To: Matthew Grooms - Planner
From: Keith Gray, PE – Senior Engineer, DPW
Date: August 29, 2017
Re: 343 Forest Ave (2017-086) – Liberty Bay Recovery - Level II Site Plan Application

The following comments/concerns are in regards to the Level II Site Plan Application prepared by Pinkham and Greer, on behalf of the applicant, Liberty Bay Recovery Center., with last plan revision submitted on August 4th, 2017. Please feel free to contact me with questions.

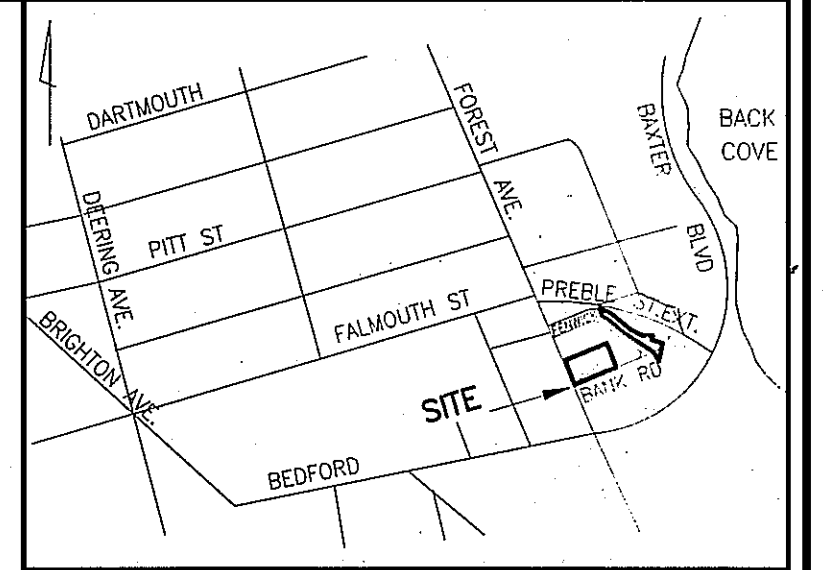
Below are Mr. Bill Scott's comments regarding the Owen Haskell plan for Whipple-Callender Architects, dated May 1, 2017:

1. Needs surveyor's stamp and signature;
2. Both parcels do not close mathematically based on the bearing, distance and curve labels;
3. Fenwick Road has been discontinued. It should not be labeled "Public". A "Public Easement" was retained as part of the discontinuance process;

4. The label about the "discontinued portion of Fenwick Road and Bank Road..." should be relocated so that it's clear that the whole road was discontinued, not just the portion included within the "Memorandum of Lease..." area;

5. There appears to be a typo under the General Notes portion of the plan. There is no deed reference listed for the owner, 164 Realty Inc.
6. There is no deed reference listed for the abutter, Palmer Spring Company.

7. General Note 2 says the bearings are based on Maine State Plane, but the North Arrow is labeled "Magnetic 1971".
8. The bearings at Forest ("S 39-45-00 E") and Fenwick ("N 50-15-00 E") appear to be on a different datum than those labeled at Forest ("N 49-30-01 W") and Bank ("S 40-25-18 W").
